File No: MC-08-1111

**RE:** Bungarabee Industrial Estate (Huntingwood West): Stage 1 – Infrastructure Works (MP 08 0225)

Scope of Works & Subdivision Plan

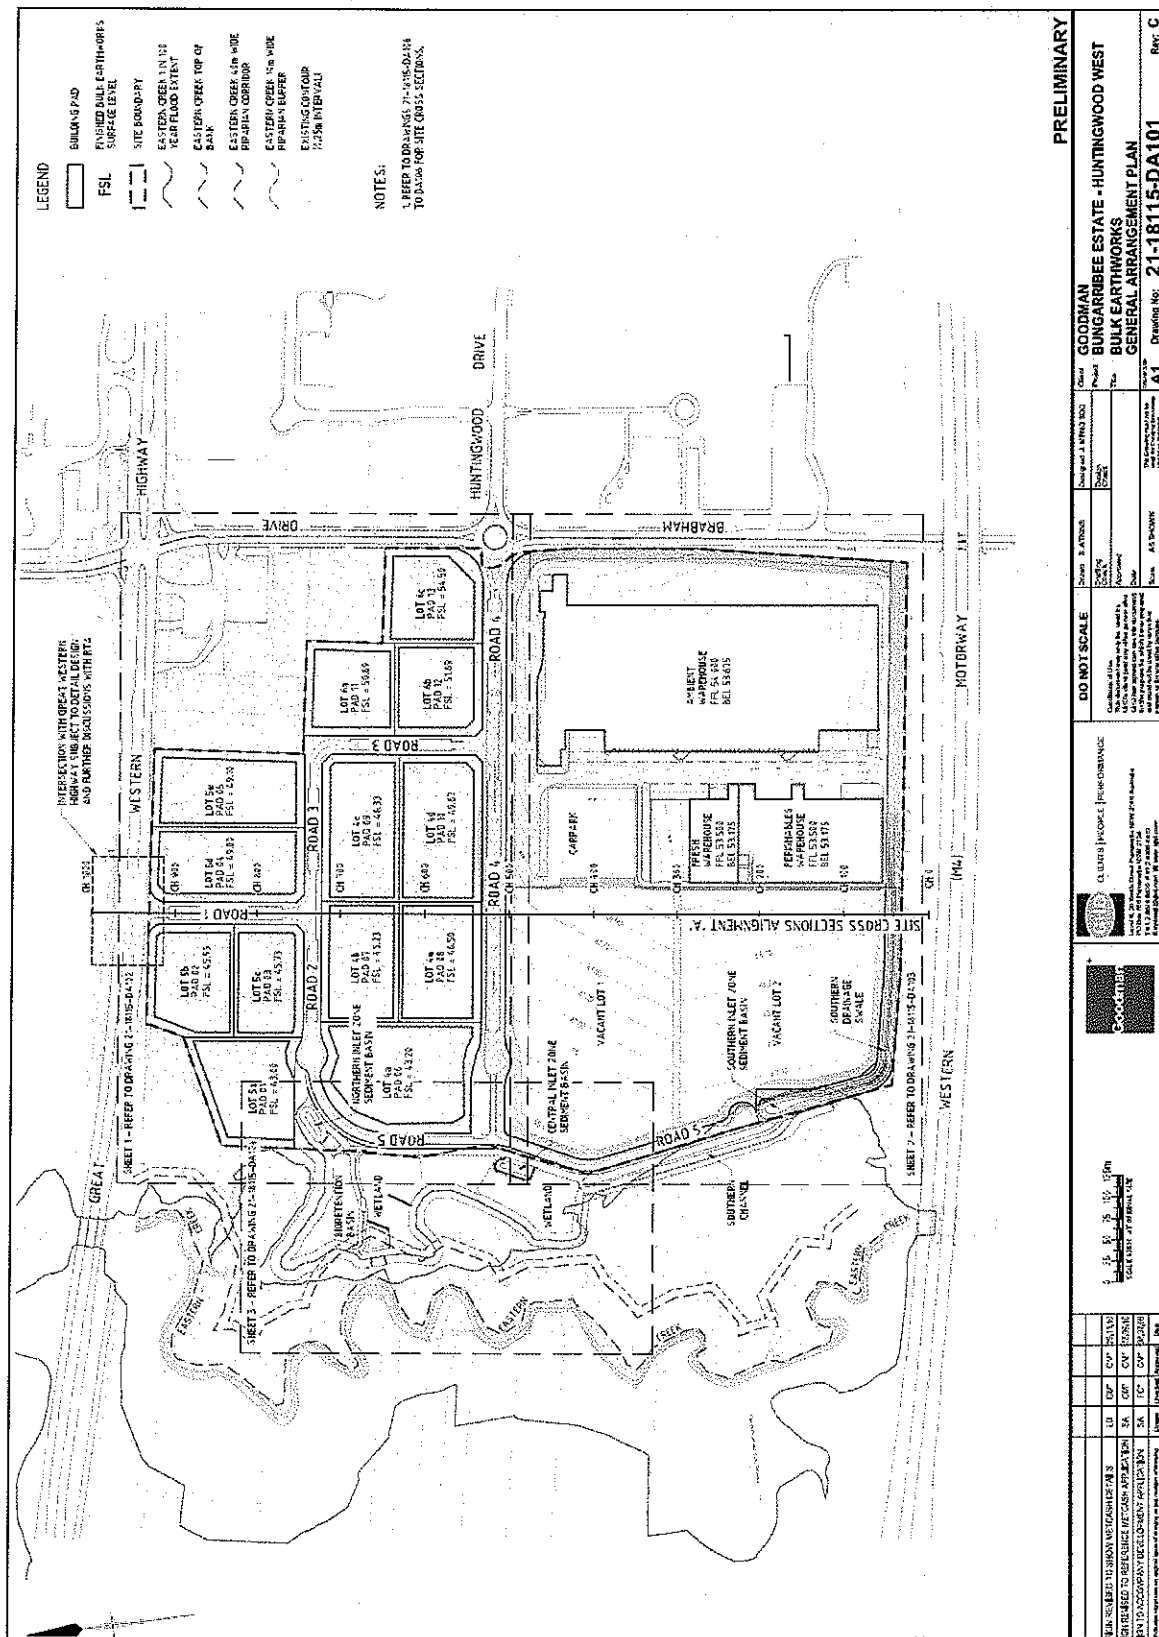
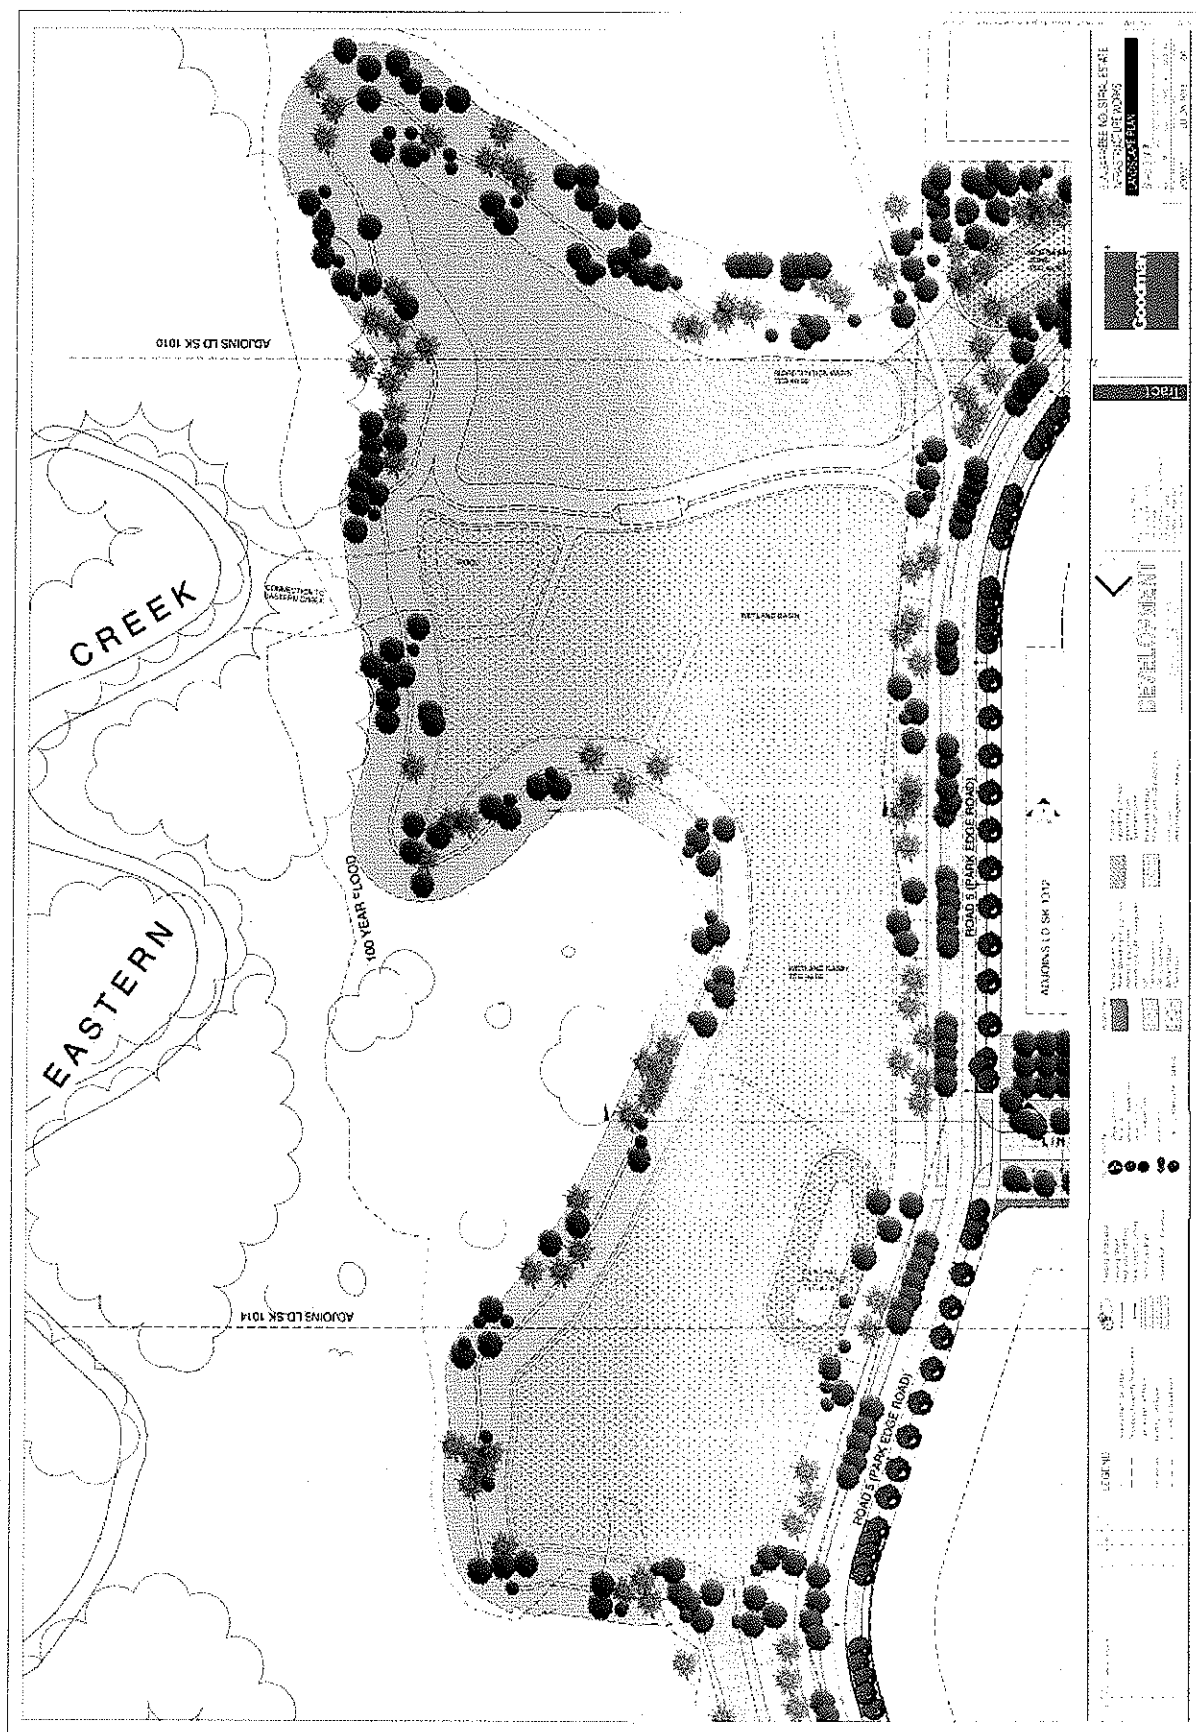
Due to the limited access opportunities for Proposed Lot 5b at the major intersection with the Great Western Highway, it is recommended that a restriction, pursuant to Section 88B of the Conveyancing Act 1919 be imposed limiting access to the southern most point away from the intersection on the frontage of Proposed Lot 5b to the internal collector road.

Furthermore, Proposed Lots 5b, 5d and 5e shall have an access denial provision to the Great Western Highway, pursuant to Section 88B of the Conveyancing Act 1919.
